OXFORDSHIRE COUNTY COUNCIL'S RESPONSE TO CONSULTATION ON THE FOLLOWING DEVELOPMENT PROPOSAL

Application no: 21/03267/OUT

Proposal: Outline planning permission (all matters reserved except for access) for the erection of buildings comprising logistics (Use Class B8) and ancillary Office (Use Class E(g)(i)) floorspace and associated infrastructure; construction of new site access from the B4100; creation of internal roads and access routes; and hard and soft landscaping

Location: South East Of Baynards House Adjoining A43, Baynards Green

JOB TITLE		M40 JUNCTION 10		CLIENT		ALBION LAND	
DRAWING TITLE							
EASTERN ACCESS GENERAL ARRANGEMENT PRE-GROWTH FUND SCHEME							
SCALE	DRAWN BY	DATE	DRAWING No	REVISION			
1:500@A1	RM	03/08/21	17213-16-GA	P0

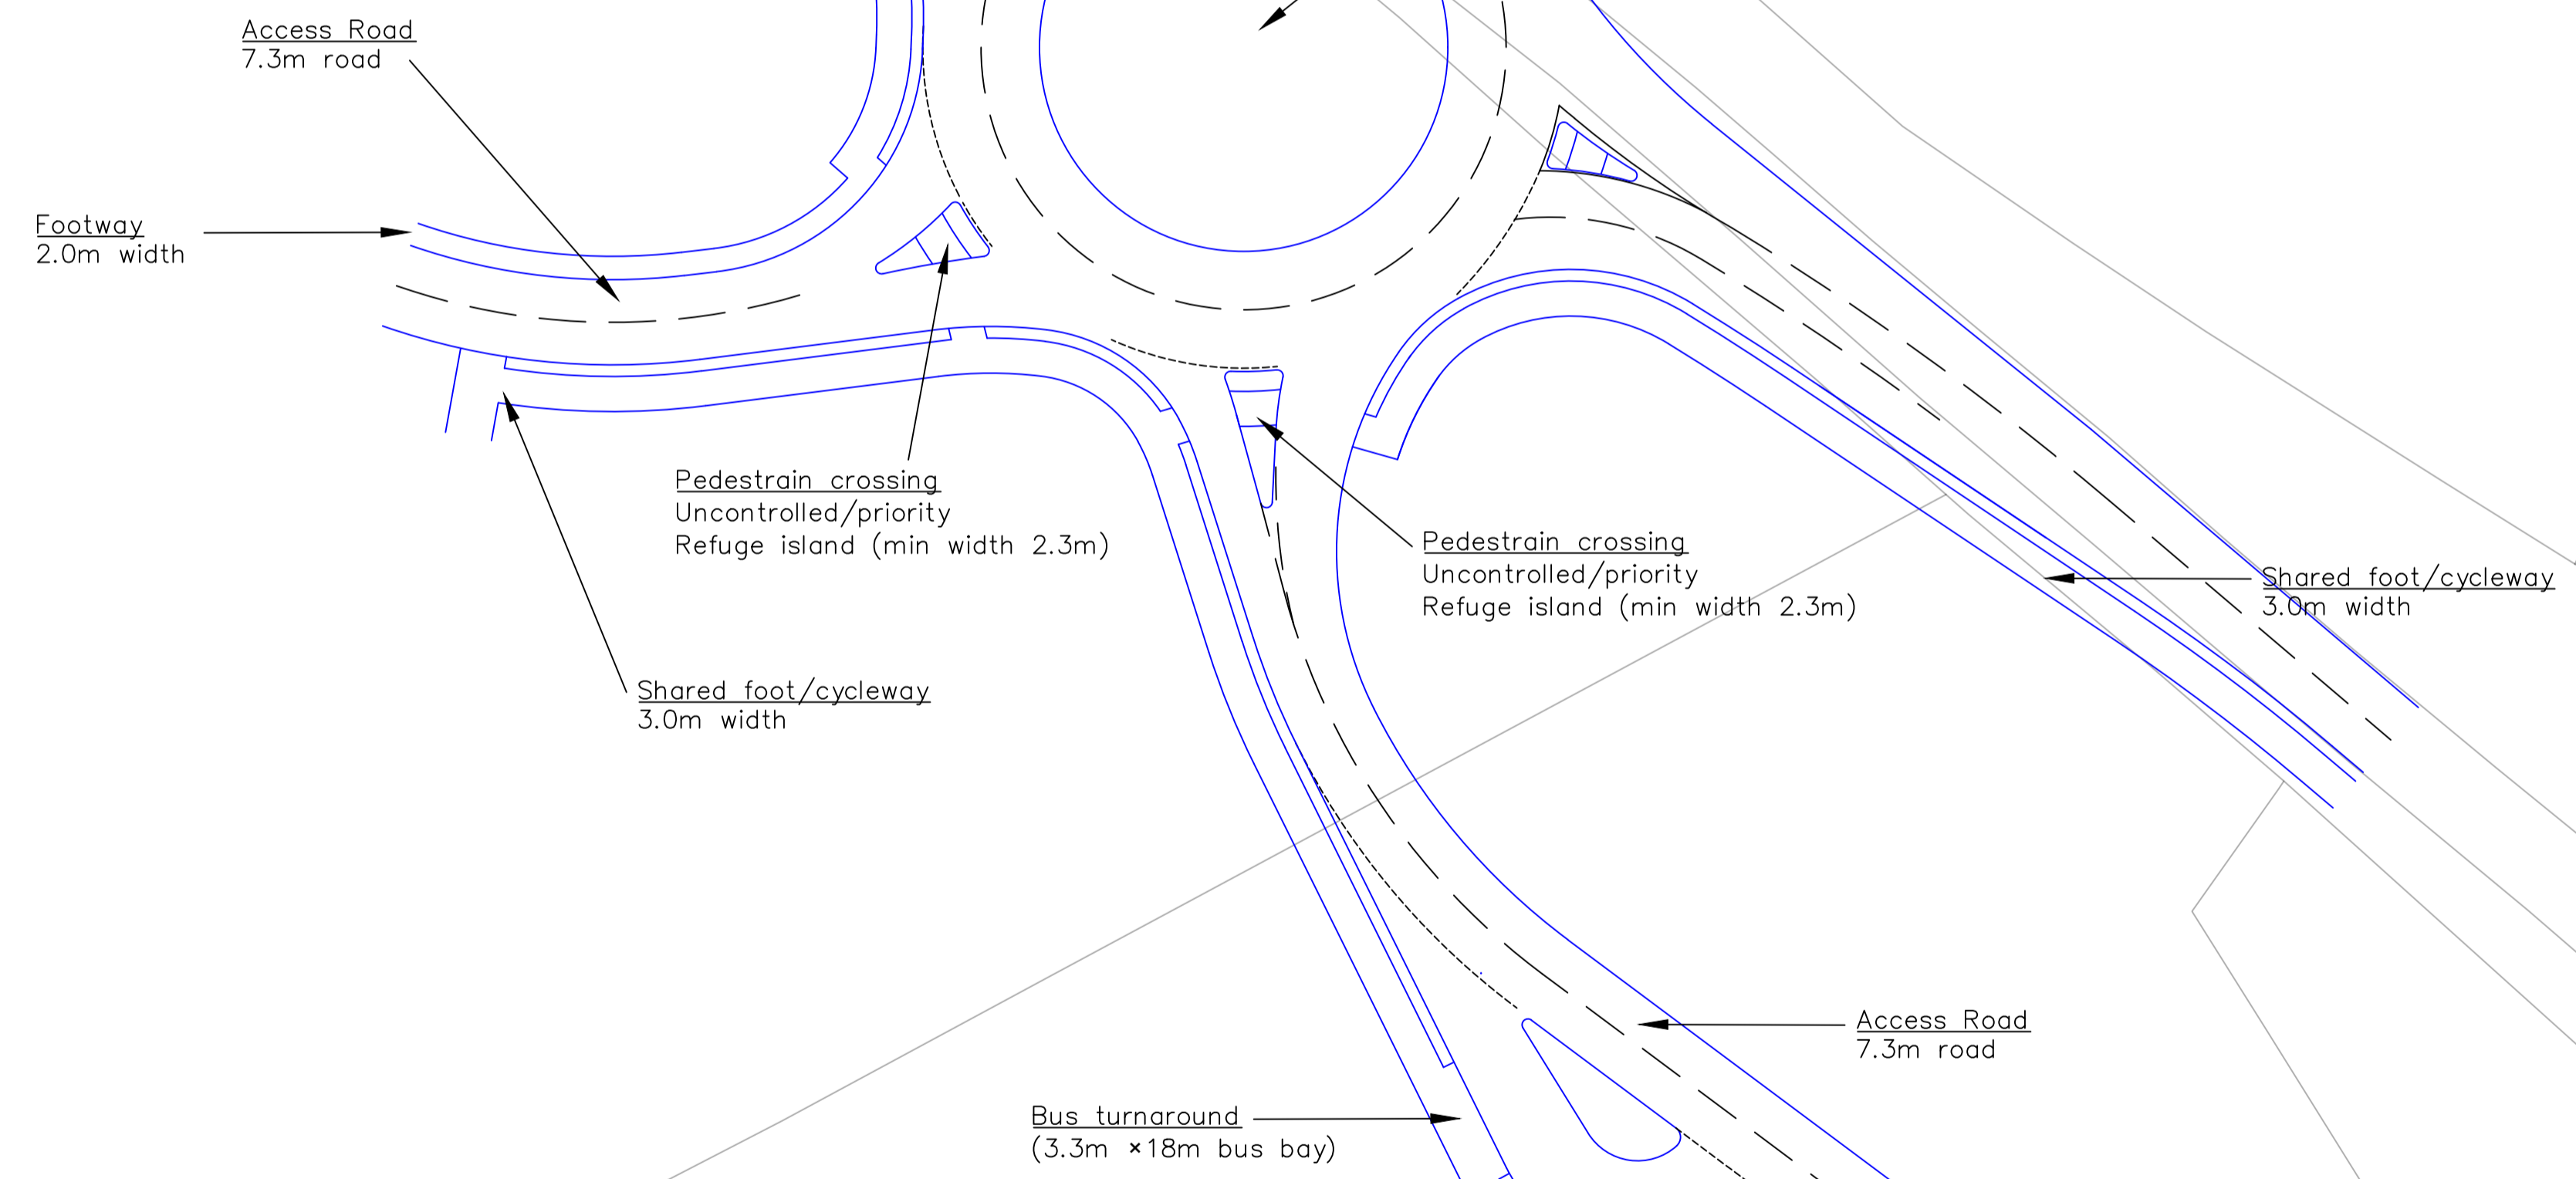
A new roundabout junction is proposed onto the B4100. A drawing has been provided showing how this meets DMRB standards. However, OCC has concerns about the geometry of the roundabout and considers that only one arm should be provided leading into the development. The arms are very close together, which makes it difficult for drivers to assess gaps, and could lead to potential conflicts. It also leads to more crossing points than necessary for the pedestrian/cycle route proposed along the frontage, to provide access to the western site. The geometry of the western access arm into this site in particular, will make it difficult for cyclists and pedestrians to judge when to cross safely. There does not appear to be any justification for having two arms off the roundabout, and the design should be amended to provide a single arm.

Further, it is very likely that the roundabout may need to be signalised, due to capacity constraints, and due to the proximity to Baynards Green. The layout, with arms close together, is likely to preclude future signalisation.

Drawings have been provided showing the new roundabouts in the context of the current highway network including Baynards Green Roundabout, and in the context of the proposed redesign of Baynards Green, which is being taken forward by National Highways and currently due for completion in 2024 (the 'Growth Deal' scheme referred to in the Transport Assessment). However, the Road Safety Audit has not taken into account the new accesses in conjunction with the new layout. This must be addressed.
